23rd November 2016

**Regarding:**  
**Project #:1010550 Case #:16EPC-40040**  
**Official Notice of Decision dated November 14, 2016**  
**Conditions of Approval and Comments Response**

SCALE: AS SHOWN
SHEET NUMBER:
A-1002

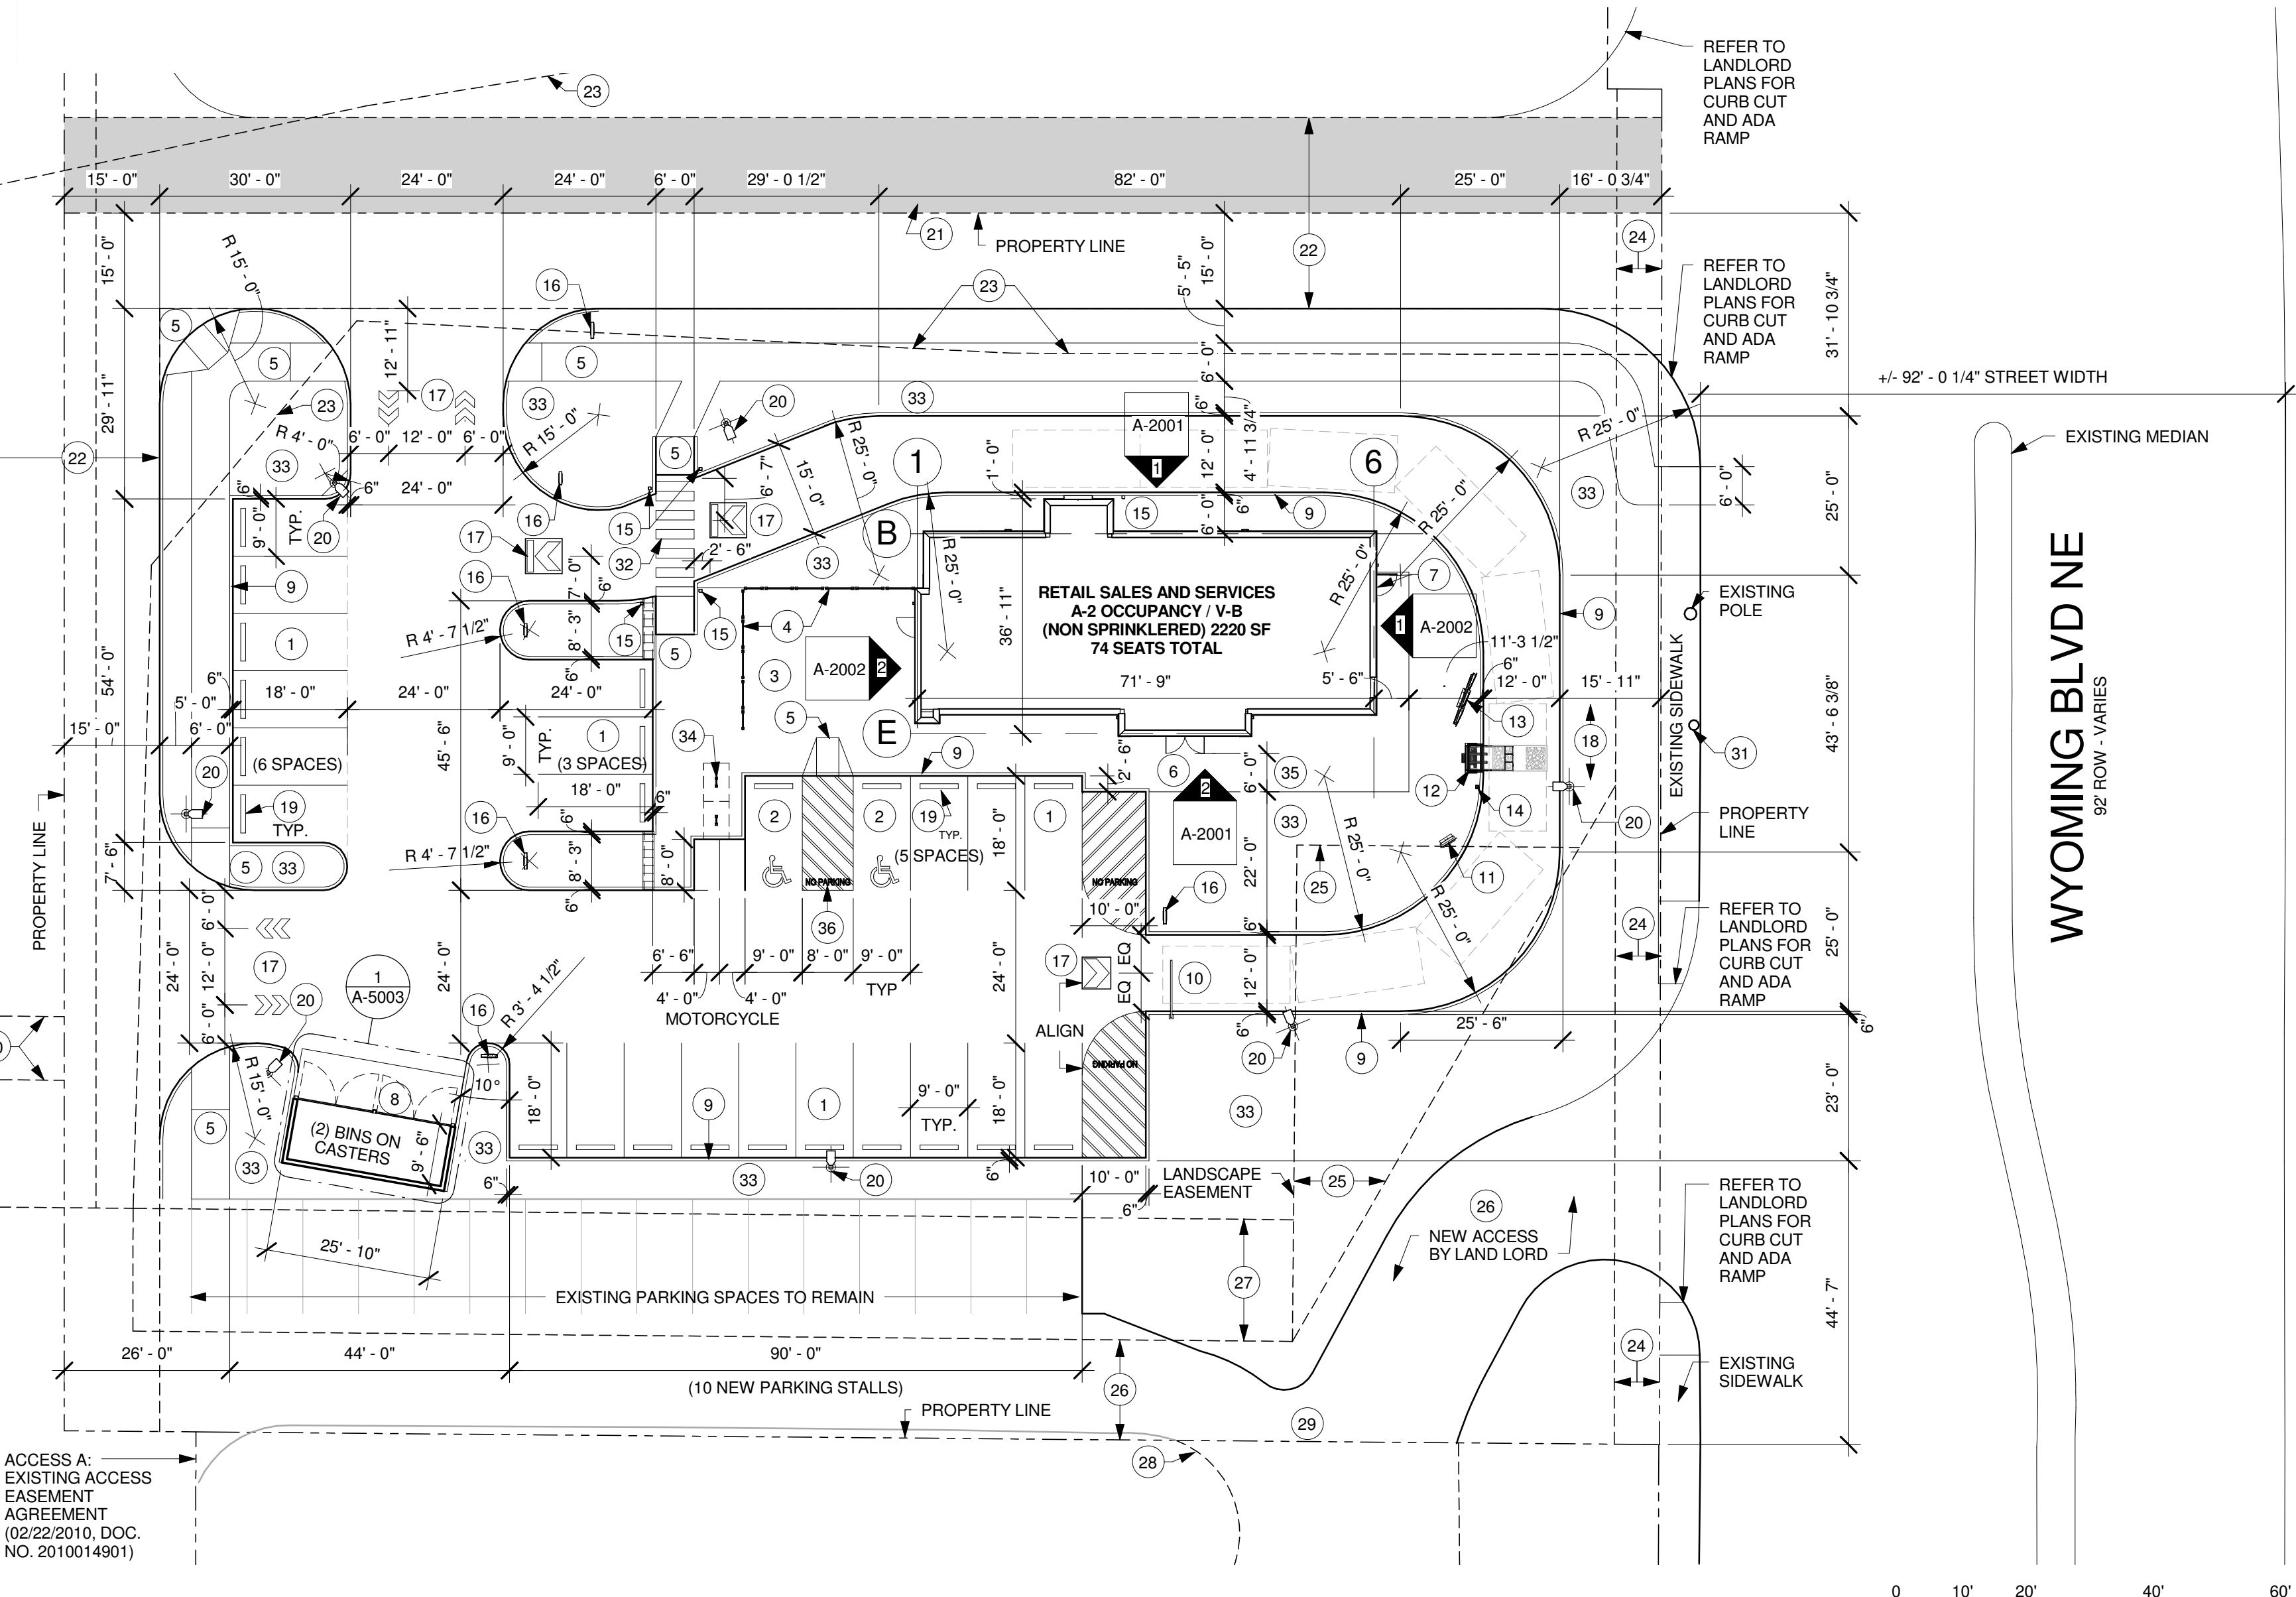
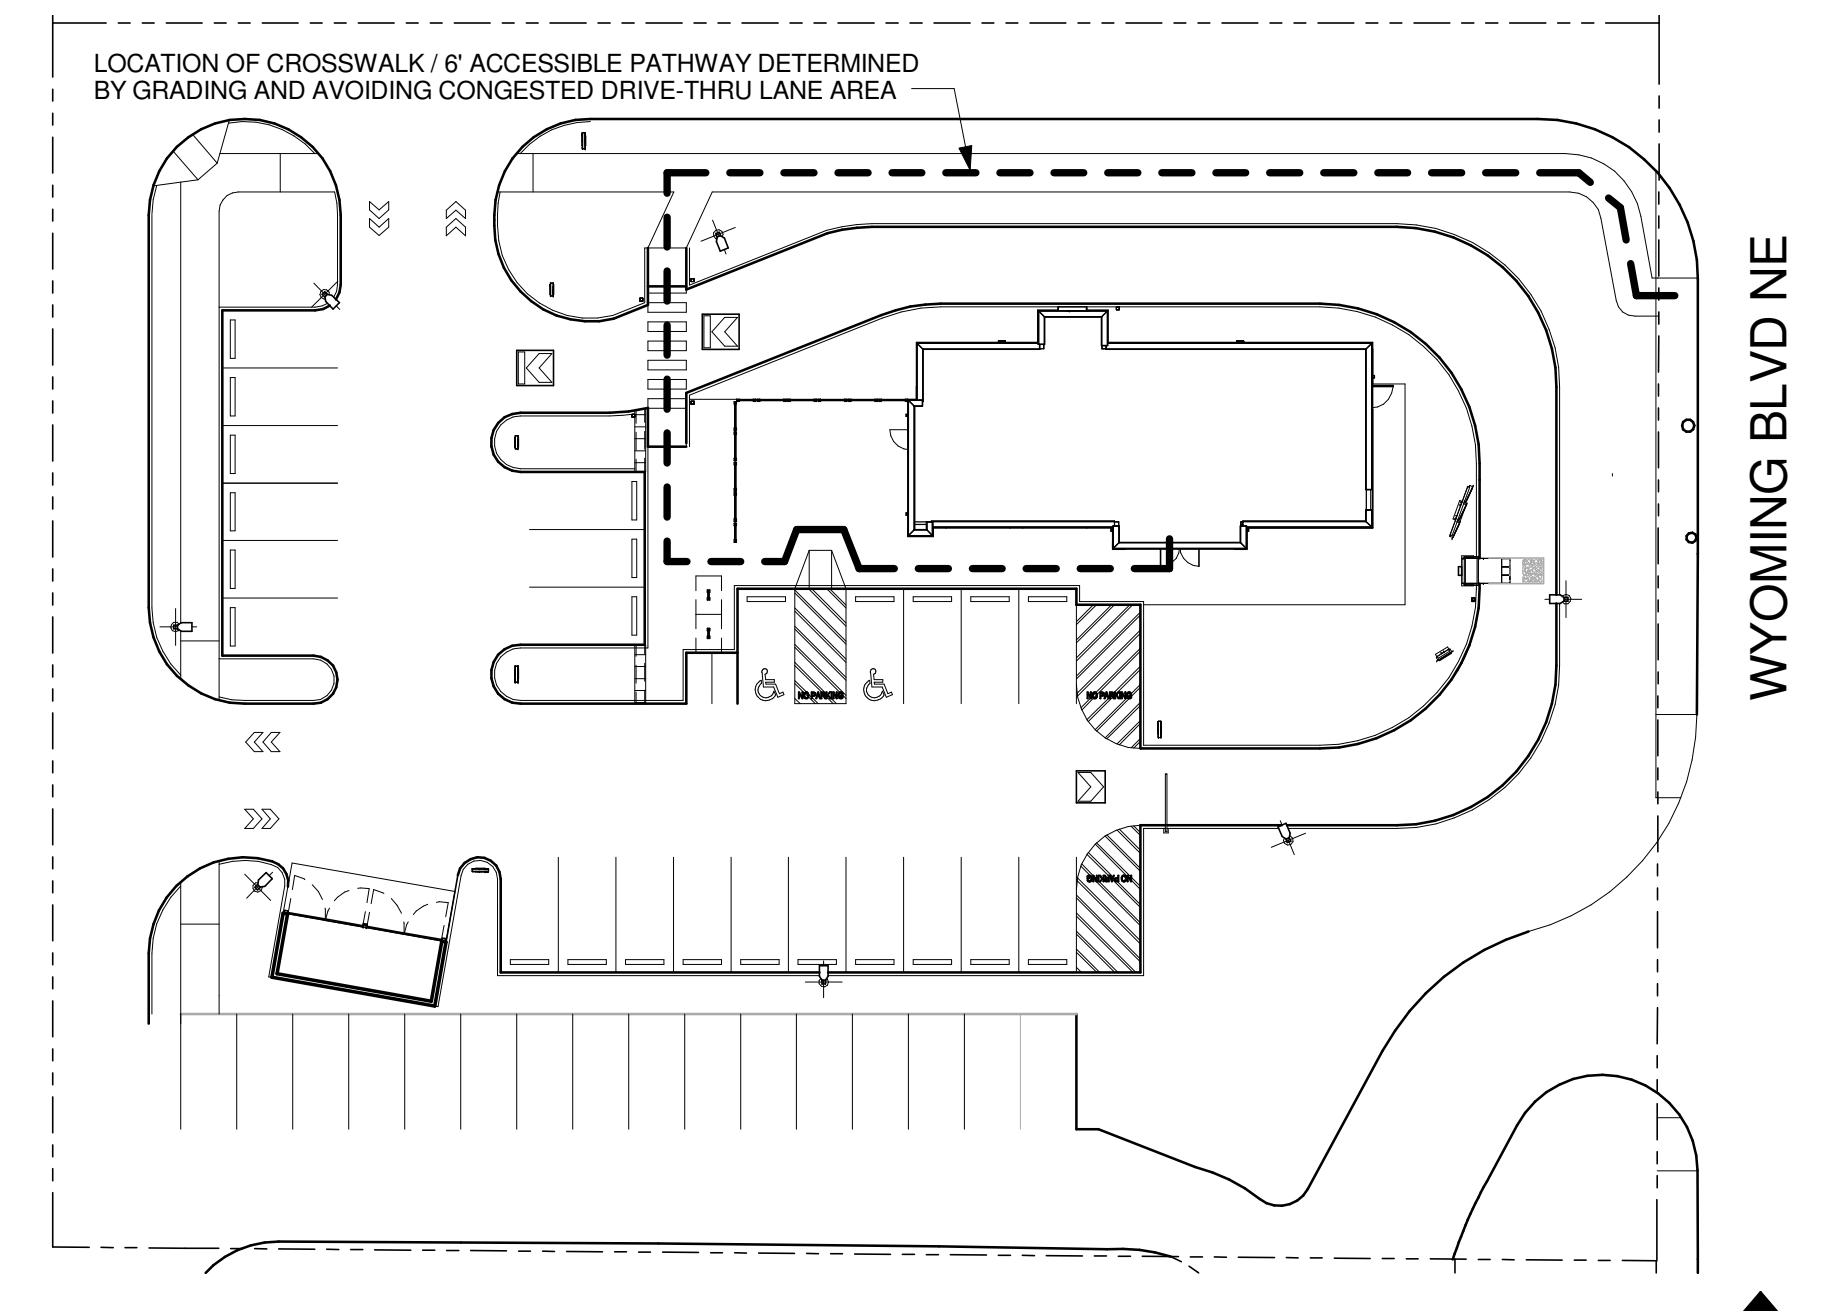
3. Refer to sheet A-1002 note 20 for modification including requested text.
4. Refer to notes 5 and 6 on sheet L1.10 for notes requested.
  - a. In addition the Landscape Calculation table on sheets L1.00 and L1.10 has been updated per site condition changes and to reflect % calculations.

- a. Refer to note C. on sheet SP-1.
  - b. Refer to note D. on sheet SP-1.
  - c. Refer to Pedestrian Connection plan on sheet A-1002. Location of crosswalk and 6' accessible pathway is limited due to the grading from Wyoming Blvd NE onto the site. Location is also set based on the least congested vehicle traffic area. There are illuminated bollards and pavement markings to draw attention to pedestrian/vehicle traffic at crosswalk. Keynote 32 on A-1002 Site Plan added to clarify pathway crosswalk will be concrete.  
Also, refer to C-0041 for ADA ramp details.

- d. Refer to notes and updated plan on sheet A-1002.
  - e. Refer to Overall Site Plan on sheet SP-1.

- a. Refer to note C. on sheet SP-1.
- b. Refer to parking calculation on sheet A-1002.
- c. Refer to note B. on sheet SP-1 and refer to phasing box note on sheet A-1002.
- d. Refer to sheet A-1002 Site Plan and keynotes 21 - 30. Also, for reference attached is the recorded plat (Precision Surveys, Inc. recorded on 10/14/2016)
- e. Refer to sheet A-1002.
- f. Detail 9/C-0040 updated to have required language. Refer to sheet C-0030 for location and detail call-outs.
- g. Refer to sheet A-1002 Site Plan and keynote 36. Also, detail 5/C-0040 has been updated.
- h. Refuse approval obtained.

6. Conditions of Approval from City Refuse Division:
- a. Refuse enclosure enlarged and relocated to provide more direct access to bins. Refer to sheet A-1002. City specifications standards used to detail refuse enclosure. Refer to sheet A-5003 for details.
